# CITY OF ALBUQUERQUE

June 6, 2005

**Re: Paradise Skies Park, Lot A1, Paradise Skies, Unit 5, Drainage and Grading Plan - Engineer's Stamp dated 5-17-05 (A11-D3A4)**

TITLE: PARADISE SKIES PARK
GRADING & DRAINAGE PLAN

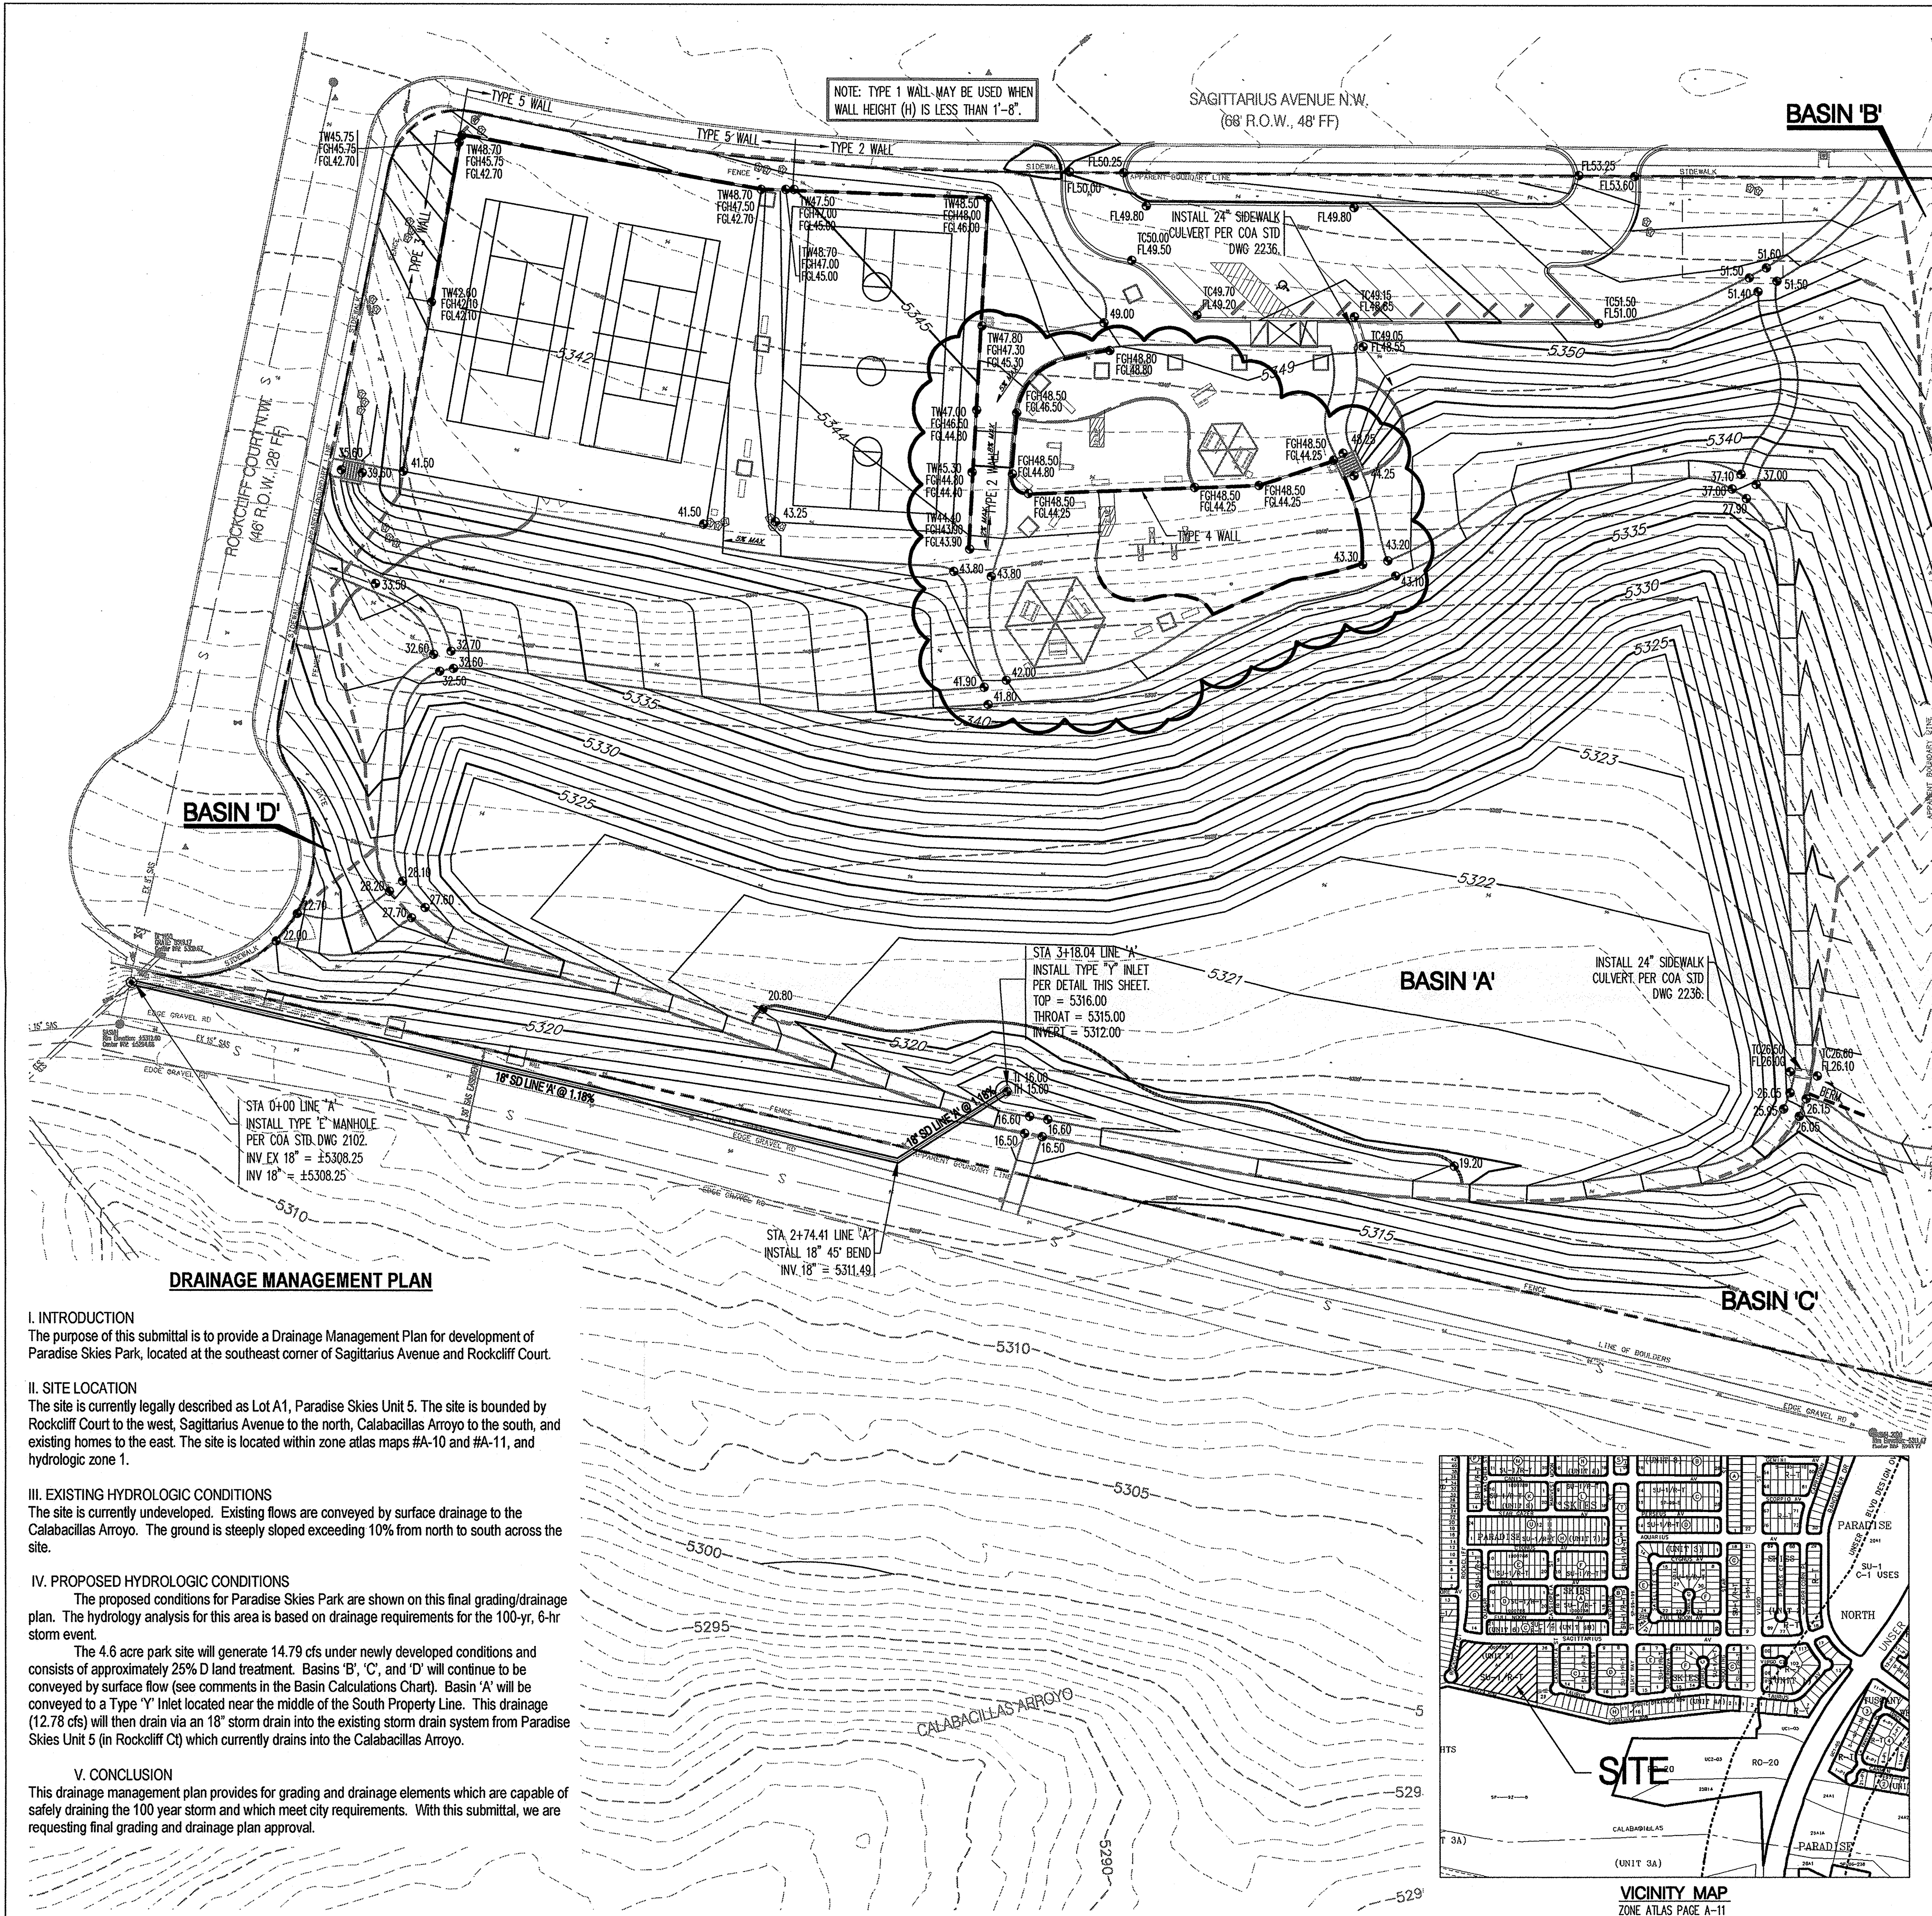
Based upon the information provided in your submittal dated 5-17-05, the above referenced plan is approved for Building Permit and Work Order provided a manhole is used for the connection to the existing storm drain.
